EPC PPR-19-054 (RMG Job No. 170915)

April 21, 2020

Re: Frontier Sptorsman - First Submittal
PPR-19-054
3385 Pheasant Lane
Peyton, CO 80831

This letter serves as a detailed letter accompanying the revisions to the Development Plan first submittal set for Frontier Sportsman's Club at the address 3385 Pheasant Lane in the town of Peyton, county of El Paso, state of Colorado. The County review comments are listed as presented in the Memorandum for the First Submittal dated February 11, 2020. Owner/develop and/or design team responses to said comments are provided below each item. Responses following "MT2" represent comment responses from the general contractor MT2, LLC., responses following "RMG" represent comment responses from the design engineer RMG-Rocky Mountain Group (Richard Lyon, PE). All resubmittal documents and supplemental information requested per the County review comment letter are acknowledged.

SHEET NAME
OVERALL GRADING KEY

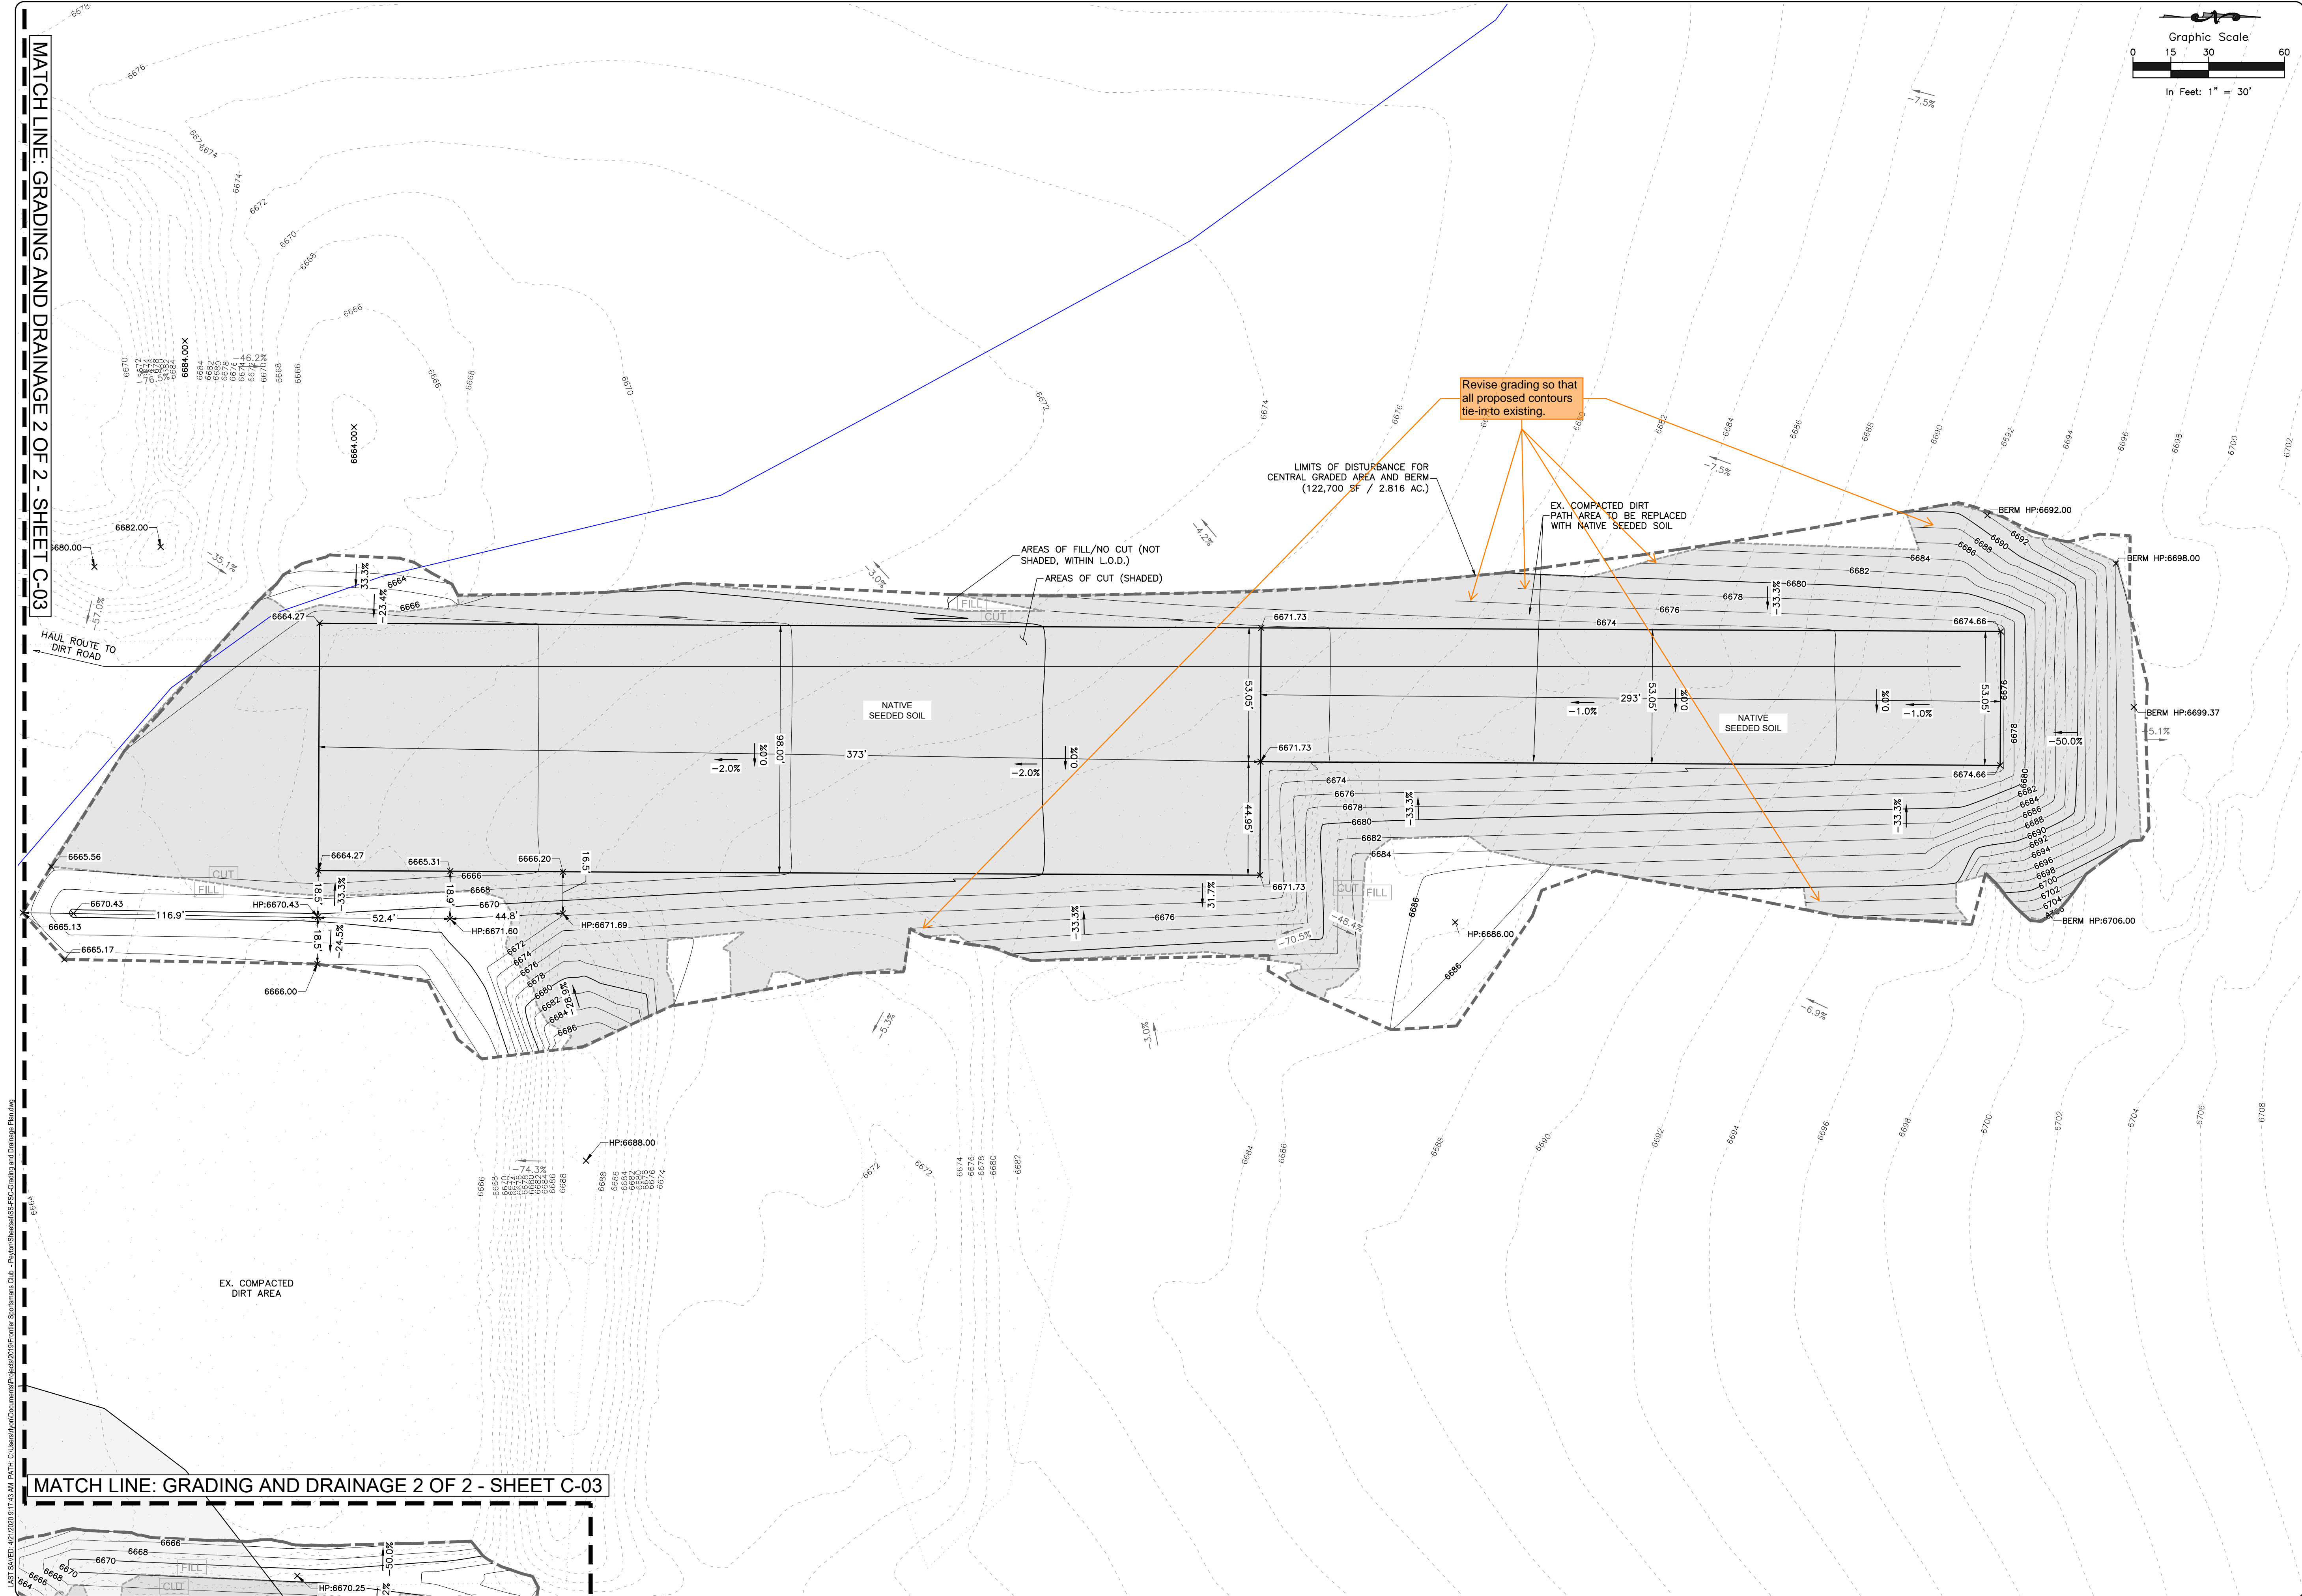
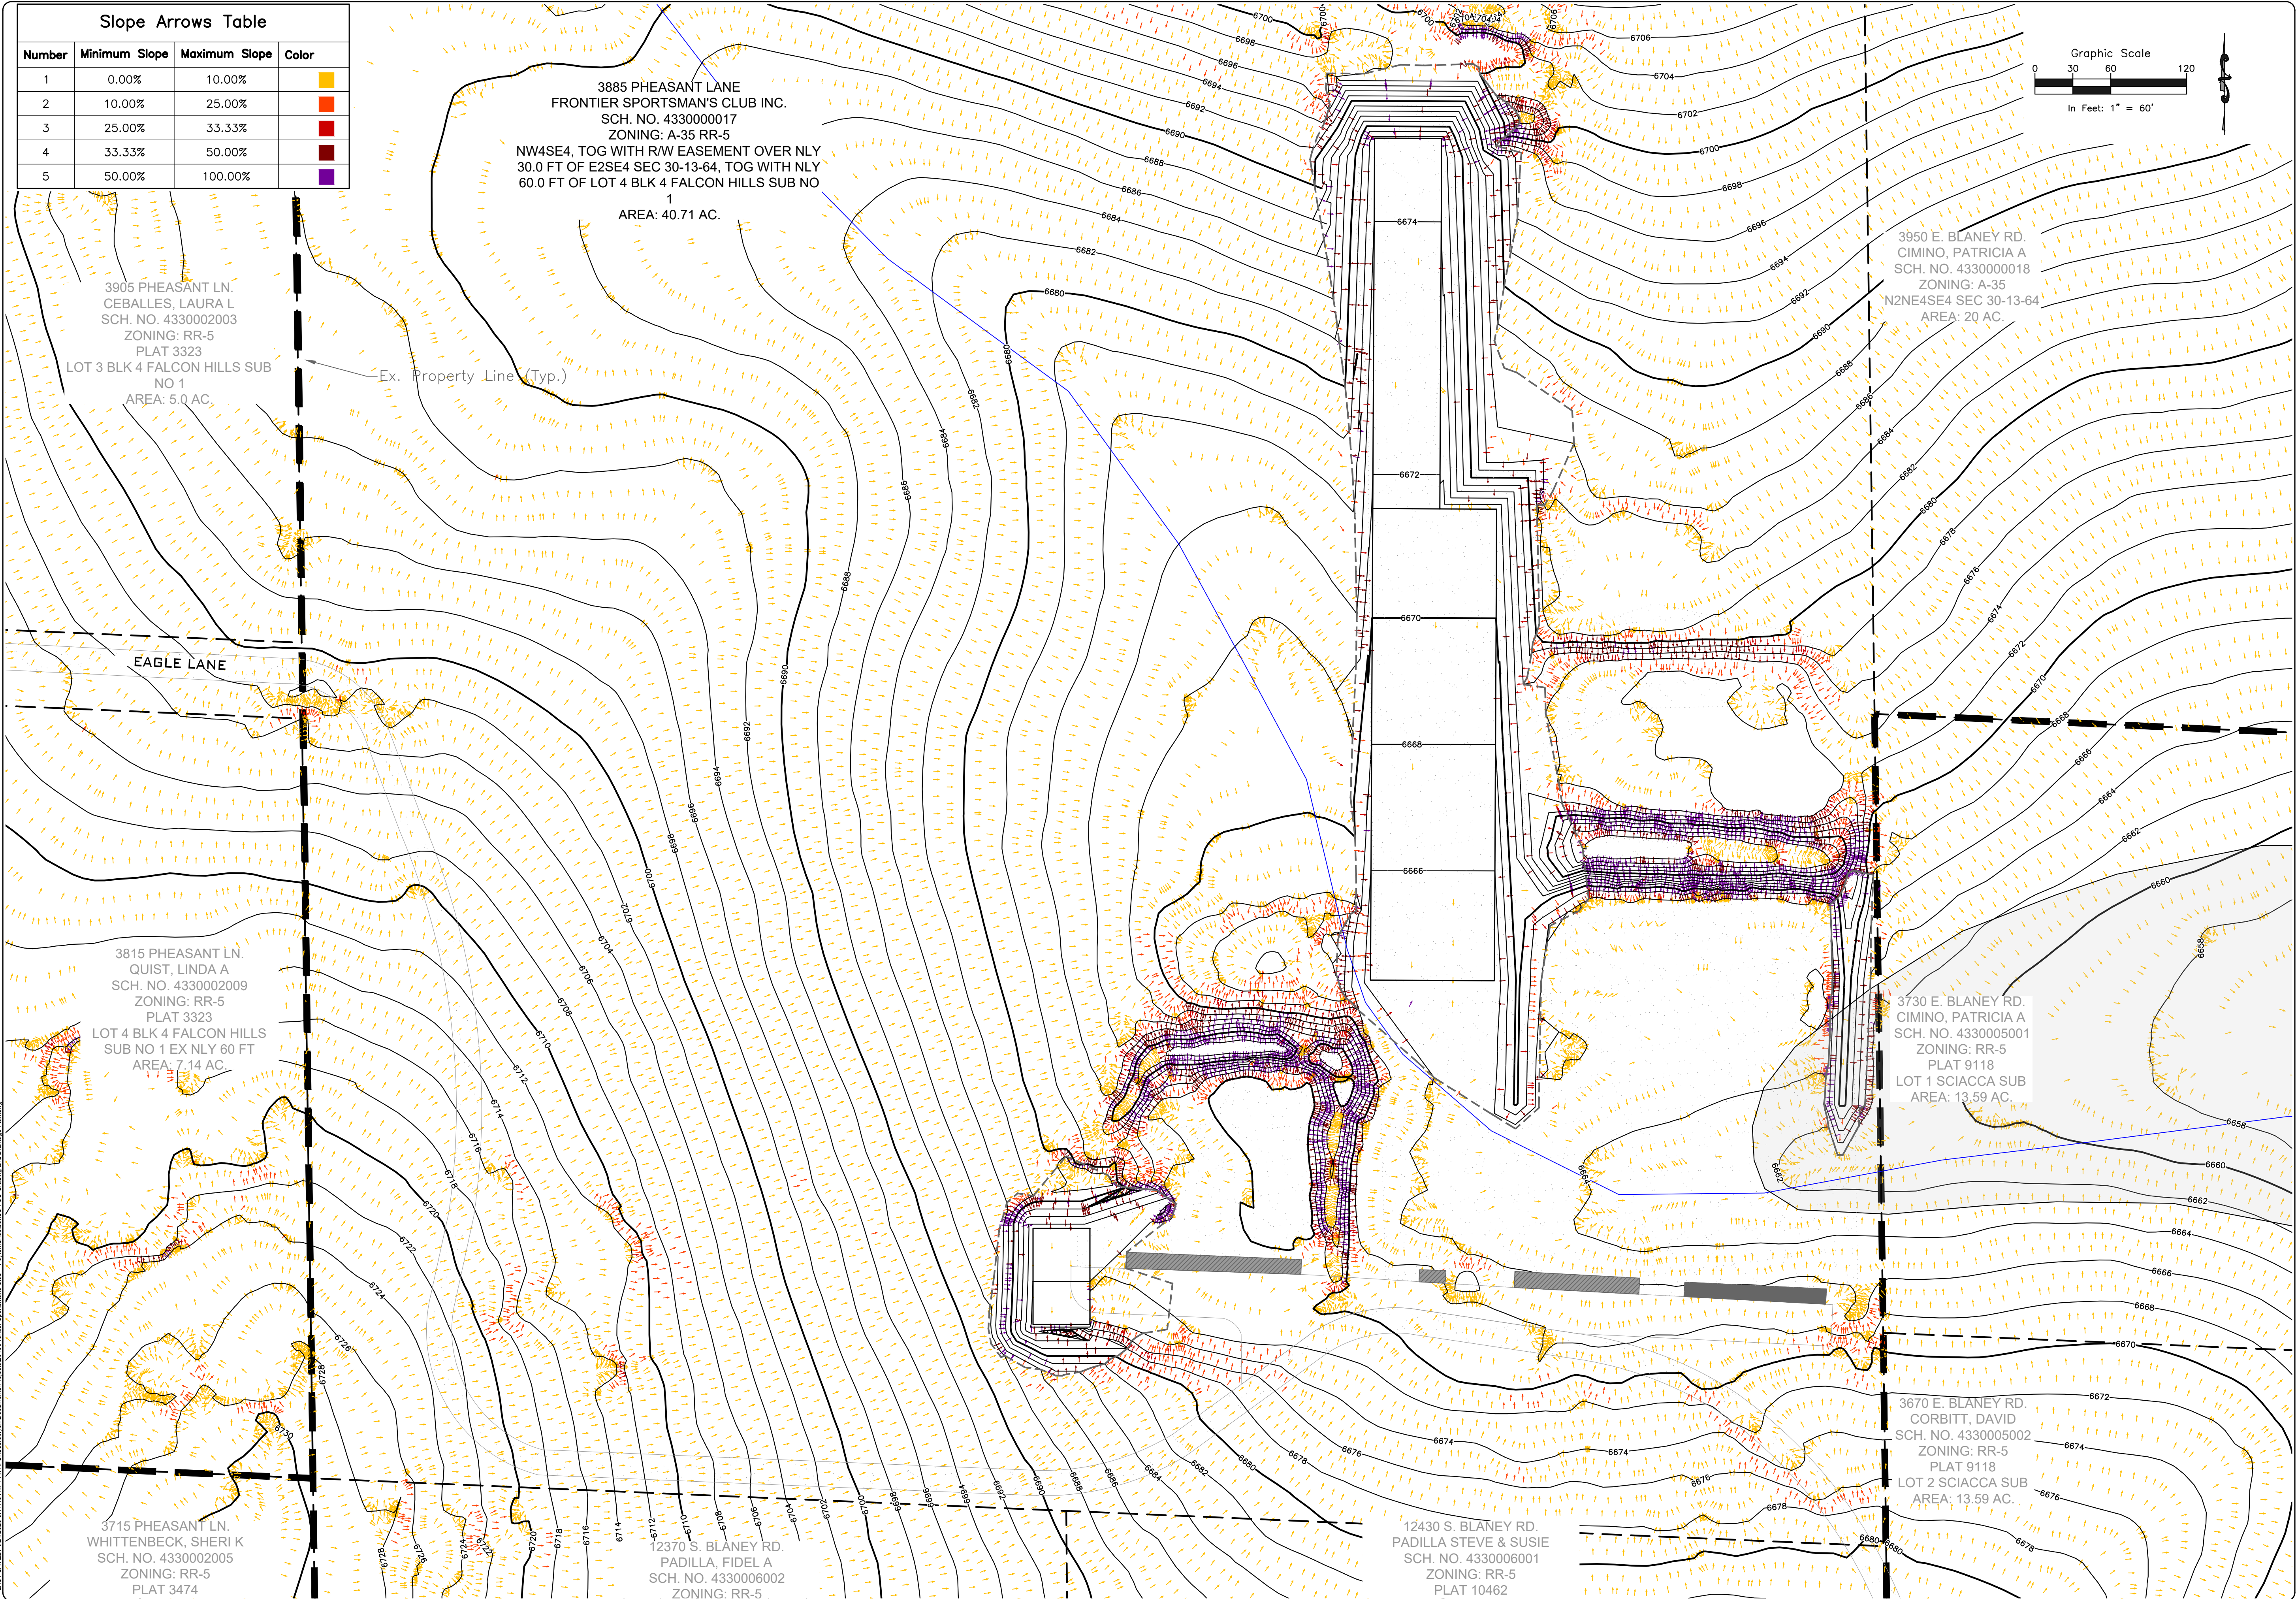
2. The proposed berm/dam on the unnamed tributary needs to be evaluated and discussed, this appears to be a Jurisdictional Dam that will need to be permitted through the State Engineers office. Additionally the water rights for the impounded water needs to be discussed and permitted.

RMG: The grading design has been revised to eliminate the berm that would be considered a jurisdictional dam.
